KITTITAS COUNTY

MEMORANDUM

TO: All Staff
FROM: Public Works Plan Review Team
DATE: July 5, 2024
SUBJECT: BL-24-00012 Blue Jay Land Company

RECORD OF SURVEY
A PORTION OF THE SW 1/4 OF SECTION 1 & A PORTION OF THE NW 1/4 OF SECTION 12,
TOWNSHIP 20 NORTH, RANGE 14 EAST, W.M.
KITTITAS COUNTY, STATE OF WASHINGTON

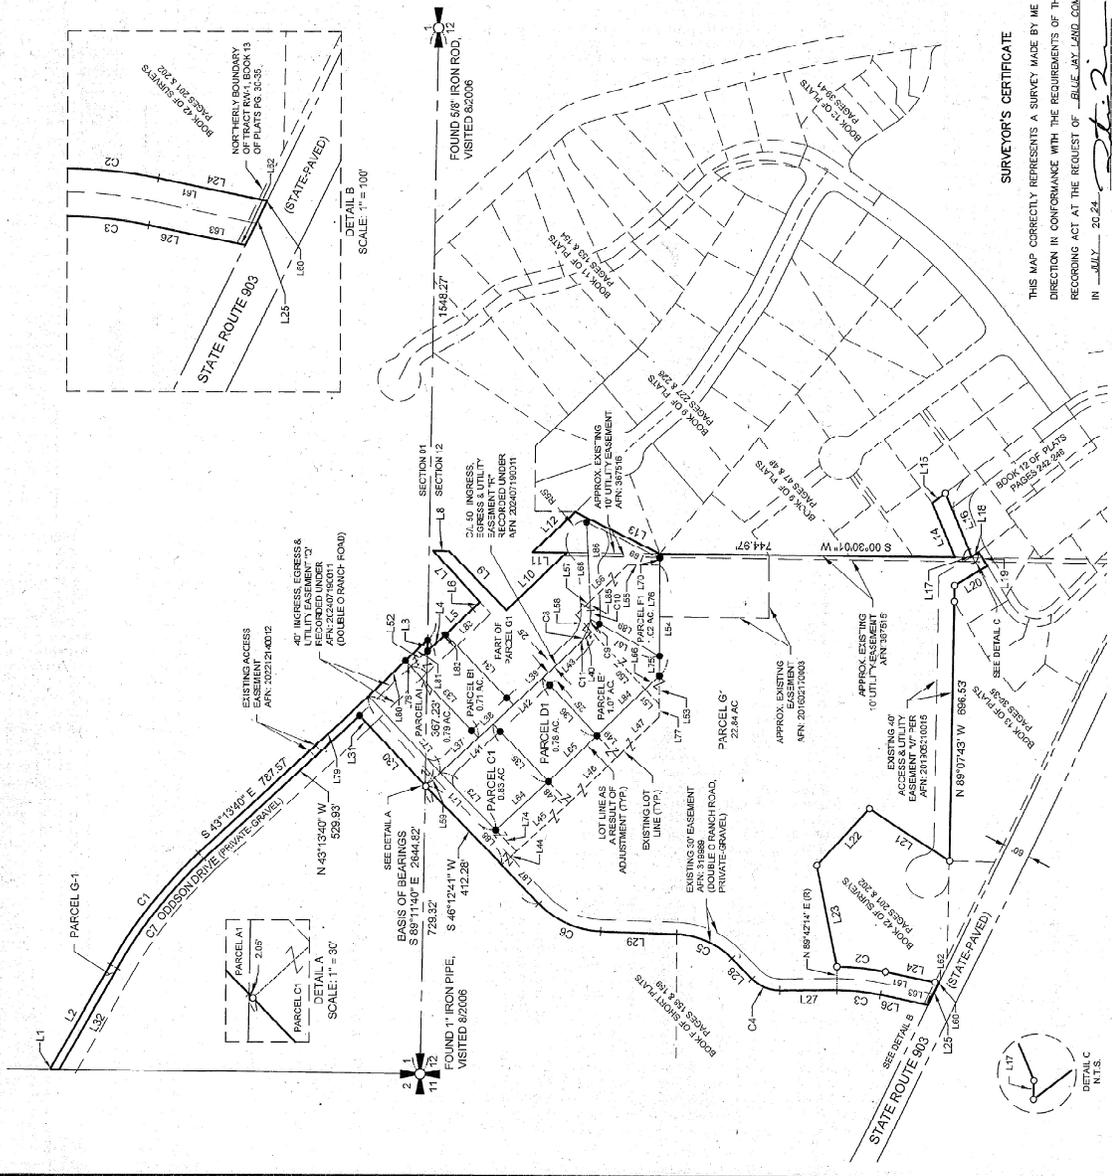
SURVEY	<p>As the application does not contain a survey map, comments are reserved until final. (KAH)</p> <p>UPDATE 07/18/2024</p> <ol style="list-style-type: none">1. At a minimum, new corners will need to be set on the new division lines between parcels, and shown on the face of the survey.2. Please label the area North of Lots E1 and F1 as "Part of Parcel G1" (or similar).3. Include widths for the varying portions of Parcel H (20', 50' and 60').4. Change the existing legal description reference from "Pages 235" to Pages 234.5. There are multiple occurrences of ambiguous line labels due to crossing easement lines or found rebars. "Crows feet" or "tick marks" could be used to

<p>clarify what these line labels are dimensioning. (Ex: L72, L33, L34... and many others)</p> <p>6. Any survey control utilized for this survey shall include ties. It is assumed that any shown corners not including ties, are for reference only, and were NOT used as controlling corners.</p> <p>7. The existing descriptions consist of 7 lots. The proposed new layout consists of 8 lots. This either requires removing a lot or proceeding with a Short Plat to address creating a new lot.</p> <p>8. Lot H as shown appears to create a unique parcel over an access road. In order to protect the county from inheriting this, a statement similar to the following will need to be included:</p> <p><i>The private road shown as Parcel H is hereby granted and conveyed to the Homeowners Association (HOA) via separate documents recorded as part of this survey. The HOA is hereby responsible for all maintenance of the road and private utilities within Parcel H. Should the HOA fail to properly maintain said parcel, the owners or their respective successors or assigns of all lots of this survey shall be equally responsible for the maintenance of said parcel.</i></p> <p>As it is unlikely such obligations and restrictions are suitable for the face of a survey, draft legal documents will need to be prepared and reviewed by the county prior to final approval of the BLA.</p> <p>9. Please include total width and surfacing for road shown on the face of the survey.</p> <p>OF NOTE</p> <p>10. Please be aware that the proposed easement 'R' is not mathematically retracable from the information shown on the survey. The easement will need a unique legal description, and not just reference the survey. The specific areas not retracable are the cul-de-sac bulb and the curves adjacent to Double O Road.</p>
